CITY OF PORTLAND BUILDING PERMIT

PERMIT ID: 2013-00431

has permission to **install Kitchen hood (tenant fit up #2012-115367)**

Proposed Use: Restaurant - Egg & I	Proposed Project Description: install Kitchen hood (tenant fit up #2012-115367)
--	---

M1

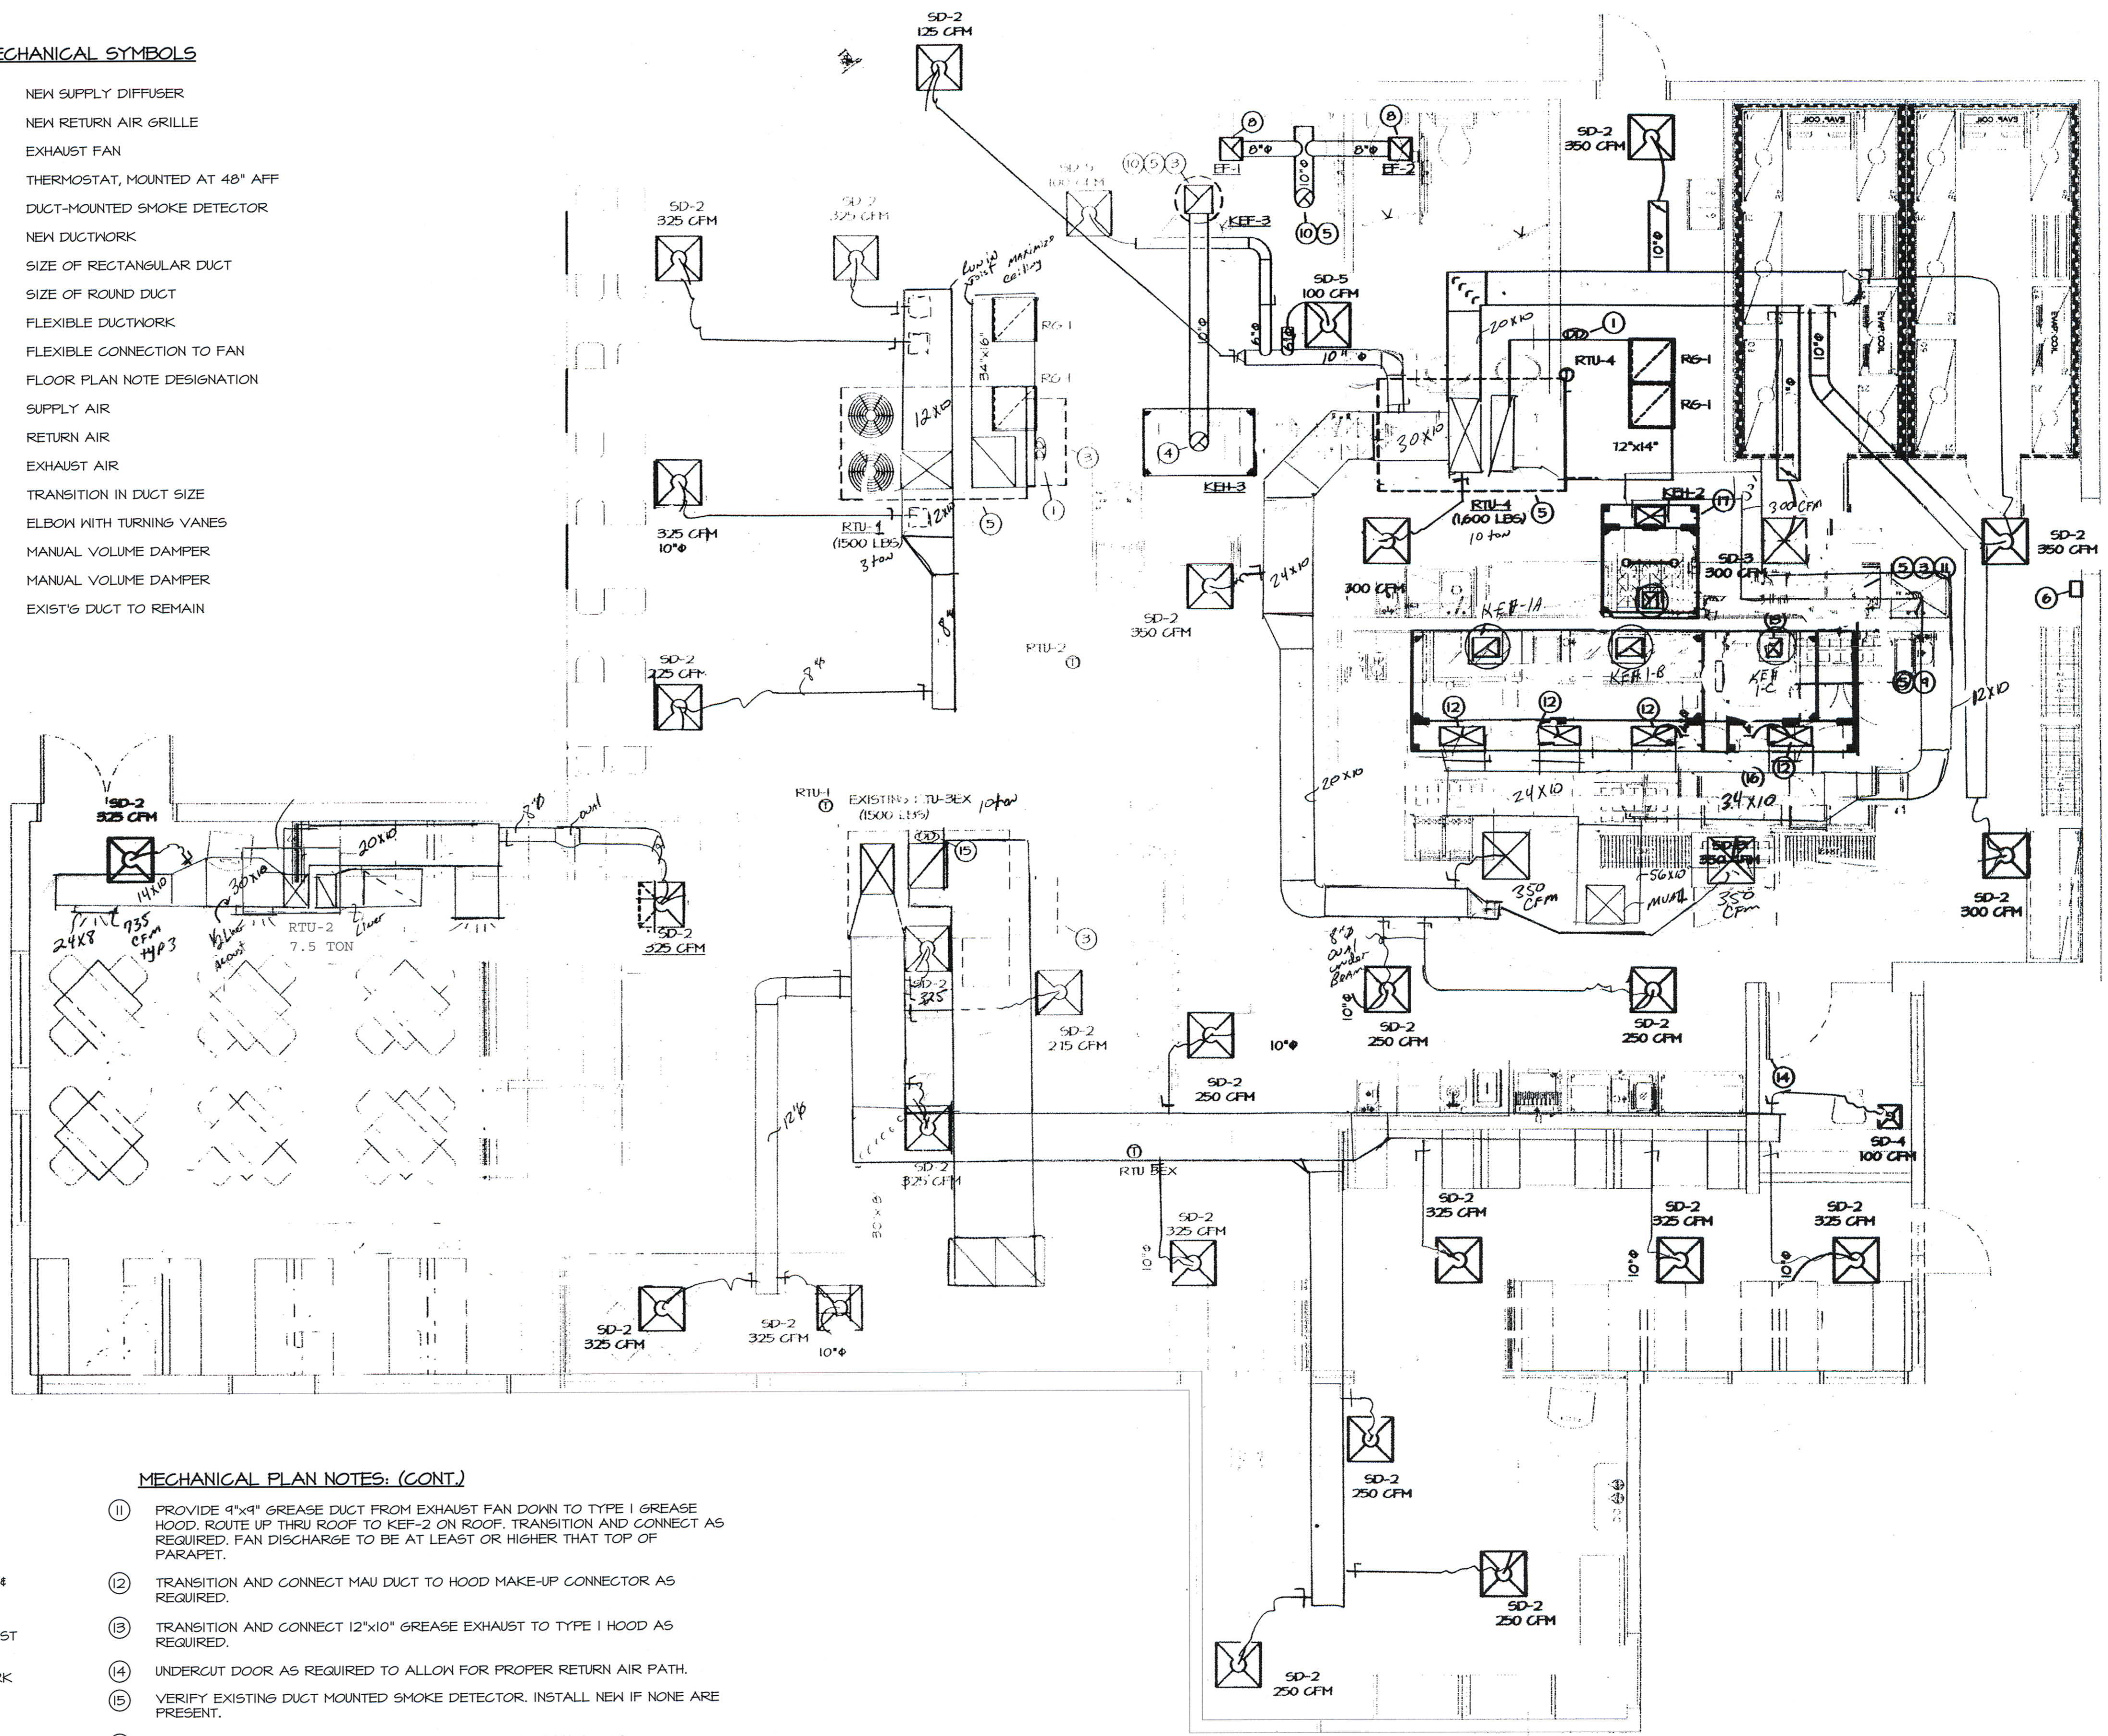
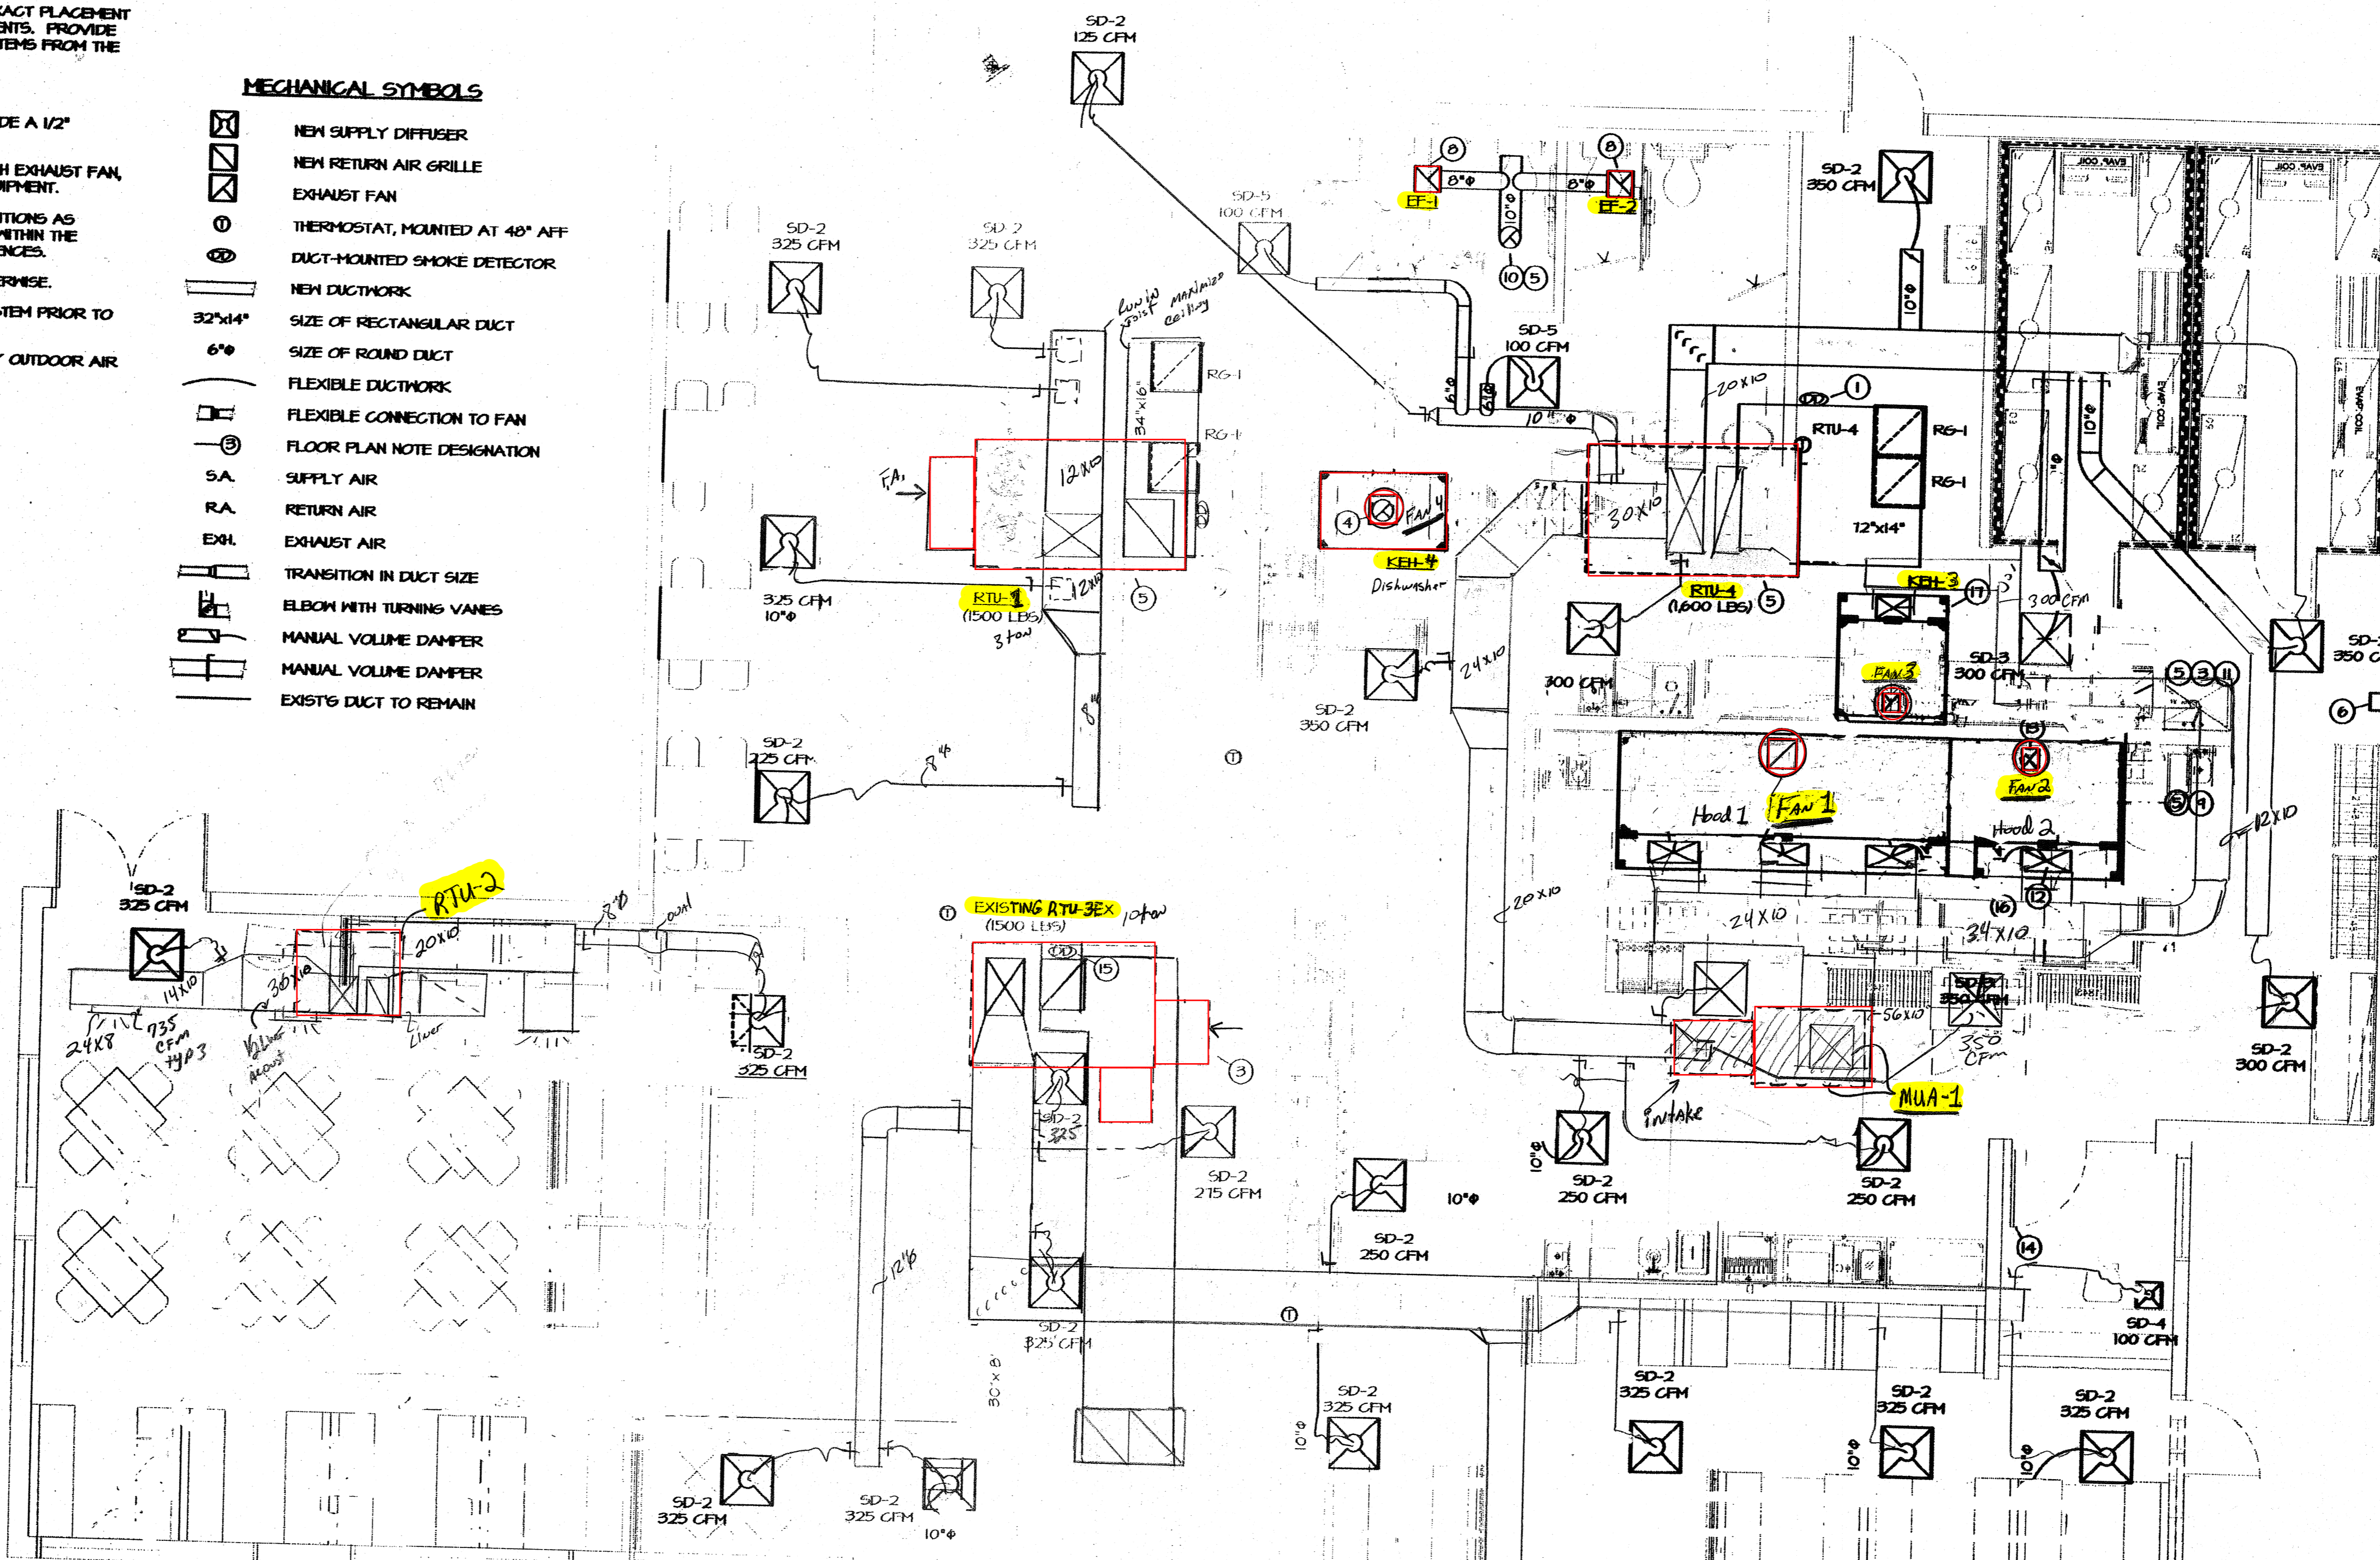
Thank you for providing the specific detail more clearly. I see the scale is 1/4" per foot, can you please indicate the distance of the make up air inlet to the closest exhaust outlet, I tried scaling it on our e-plan reader and it looks close, 9'-83/4".

Jeanie, from the exhaust fan to the make-up air unit ,the distance is 10'-1"1/2
Ed/ landry french
